M25 junction 28 improvement scheme

TR010029

9.84 Applicant's comments on Transport for London's response to ExAWQ2

April 2021

Client	MR L JONES & MRS K JONES			
	FOR APPROVAL			
Project	GROVE FARM ACCESS, JUNCTION 28 M25 NORTHBOUND SLIP LANE			
	SUGGESTED ALTERATIONS TO GROVE FARM HIGHWAY ACCESS			
Status	Drawn	PL	Scale	1:500
Sheet Size	A3	Date	JAN 2021	Rev
Drawing No.	REDW-3396-111			Rev

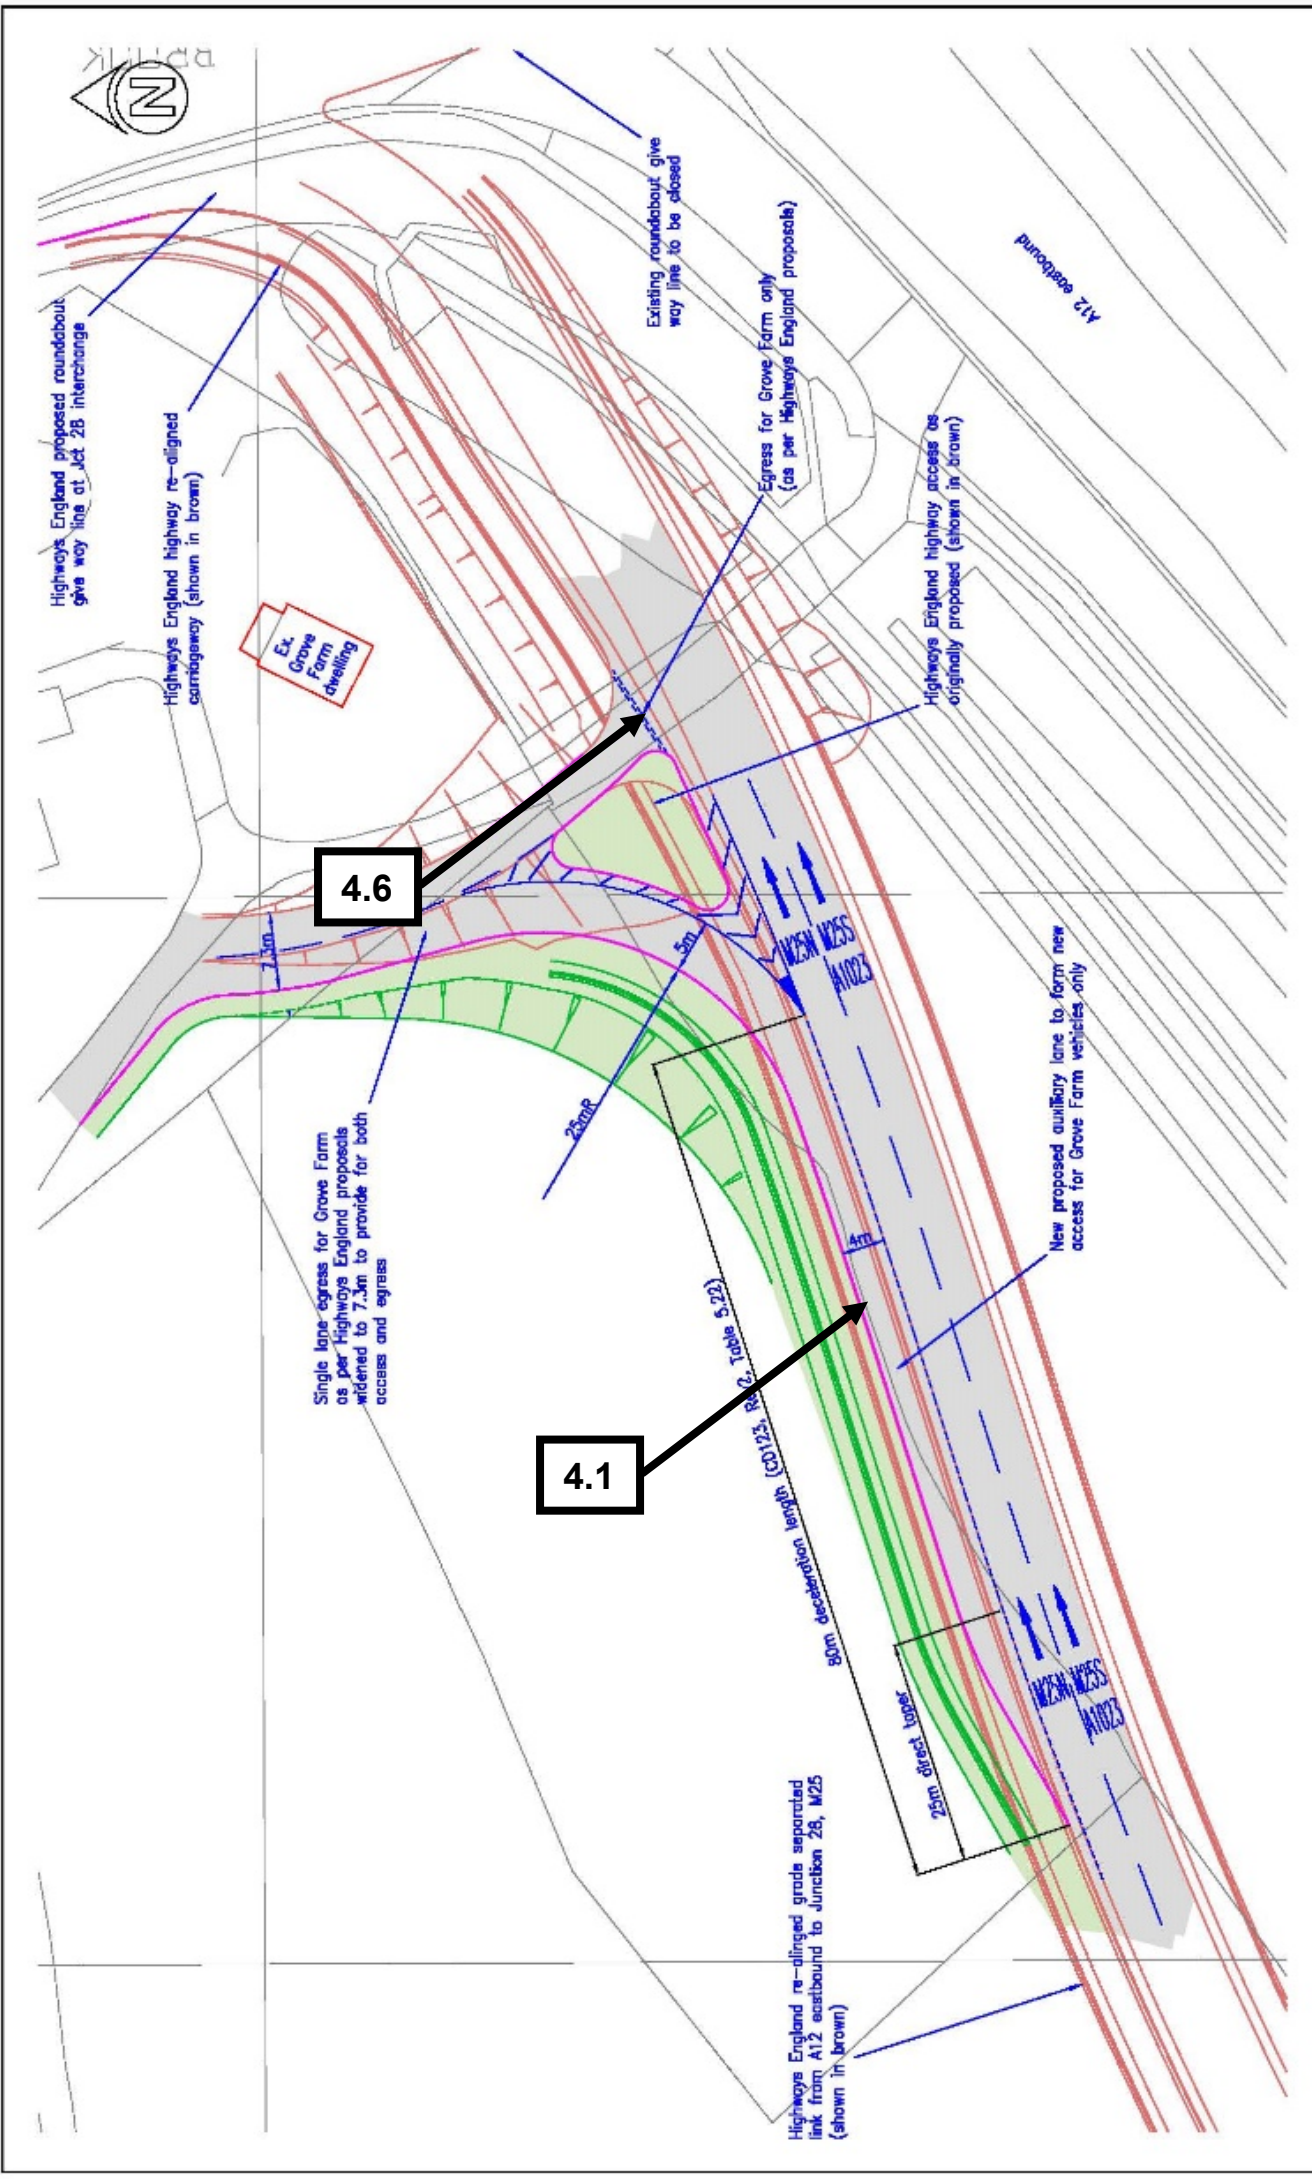
TA 2.3 Proposed Access / Egress at Grove Farm The Applicant Transport for London London Borough of Havering	The representatives of Mr & Mrs Jones submitted revised proposals at Deadline 4 [REP4-036] for access / egress to and from their property. Provide comments on these proposals.	TfL has reviewed the proposed new Location for the egress from Grove Farm onto the new A12 eastbound off slip road set out in the plan in document REP4-036. This results in the egress being Located approximately 120 metres from the proposed stop Line at the roundabout instead of the current distance of approximately 70 metres, an increase of 50 metres. TfL has not identified any immediate safety concerns with this proposal when compared with the Layout currently proposed by the Applicant. It would be important to demonstrate that there is sufficient visibility to and from the new egress Location for the required design speed. The alternative egress Location may require a new or revised departure from standards. TfL is not able to comment on the proposal in terms of construction feasibility or environmental impacts and we would expect the Applicant to consider these alongside a full assessment of road safety implications.	Noted
